Application No: CM/70/21/PL
Site Address: Land at Wren Cottage Horsemere Green Lane Climping BN17 5QZ
Description of Works: Subdivision of the plot and construction of 3 detached bungalows with associated parking, access and landscaping (resubmission of CM/17/21/PL). This application is in CIL Zone 3 and is CIL Liable as new dwellings.

Jennifer Pollitt
Environment Officer
Environmental Strategy
Chichester District Council

Proposed Site Plan

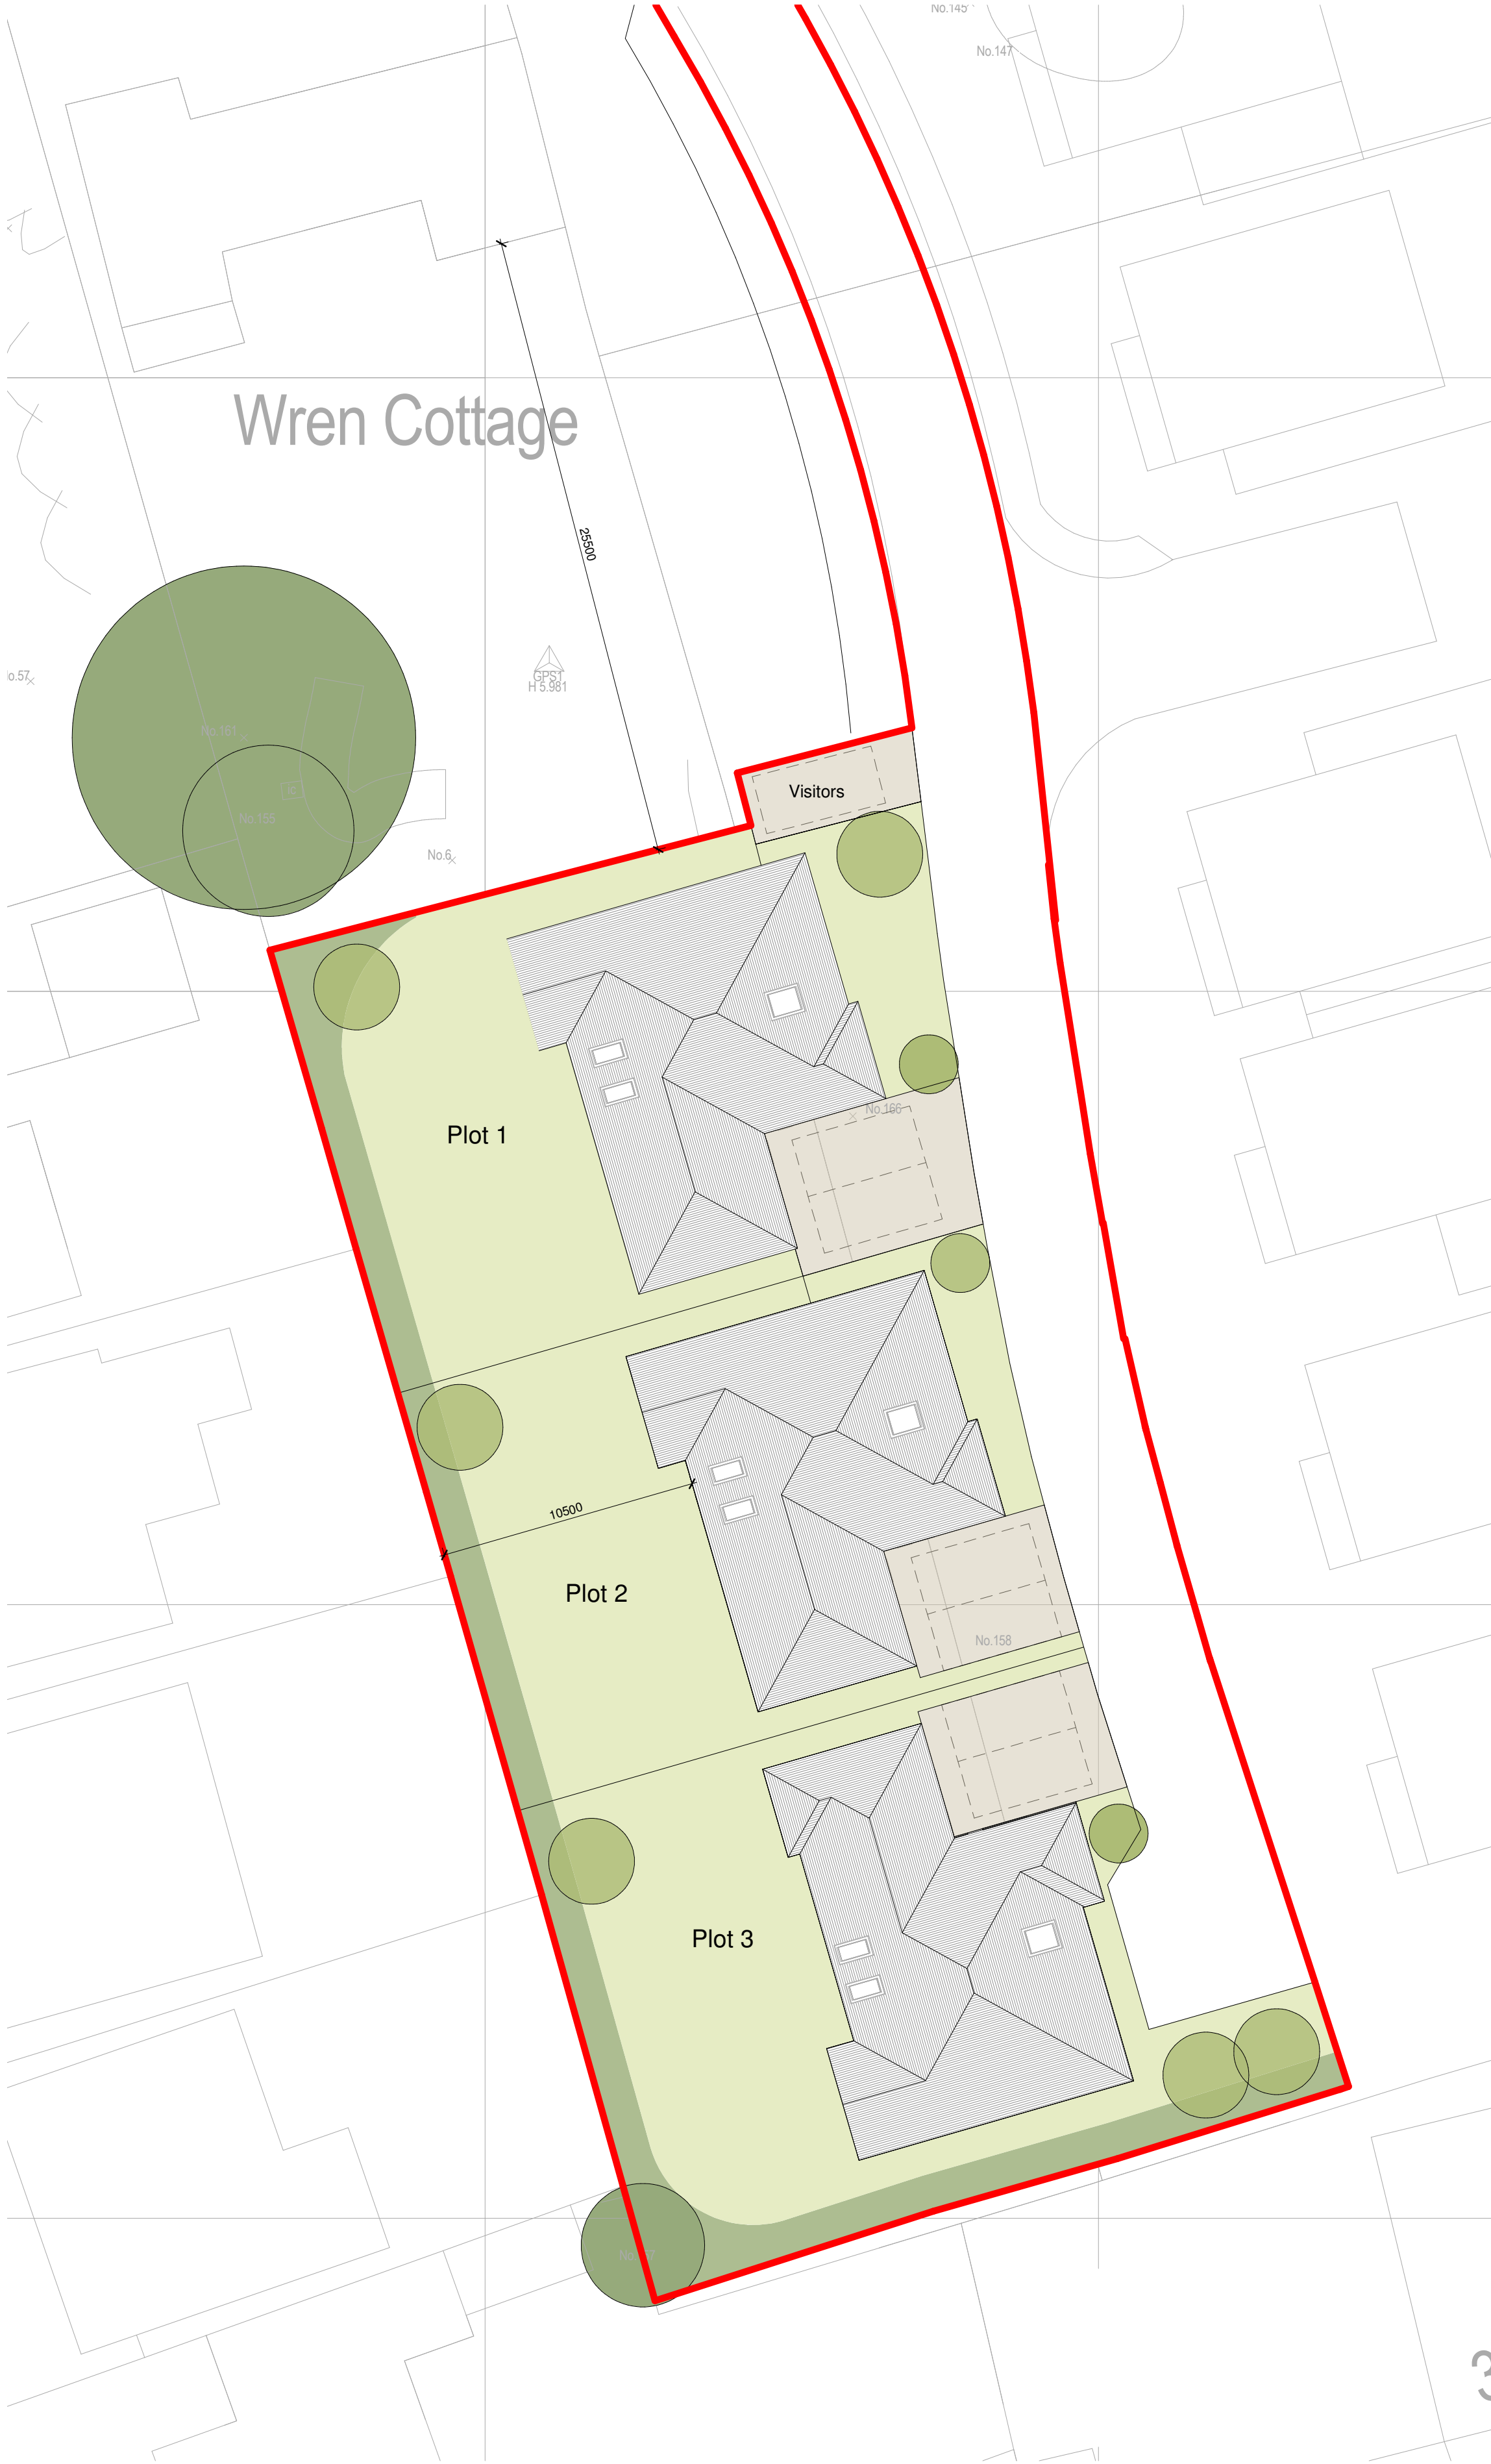
We require that a bat brick is integrated into the building onsite facing south/south westerly positioned 3-5m above ground.

We would like a bird box to be installed on the extension / and or tree within the garden of the property.

The enhancements detailed in the Ecological Impact Assessment (November 2021) are suitable and sufficient for the site. These should be incorporated into the site plans.
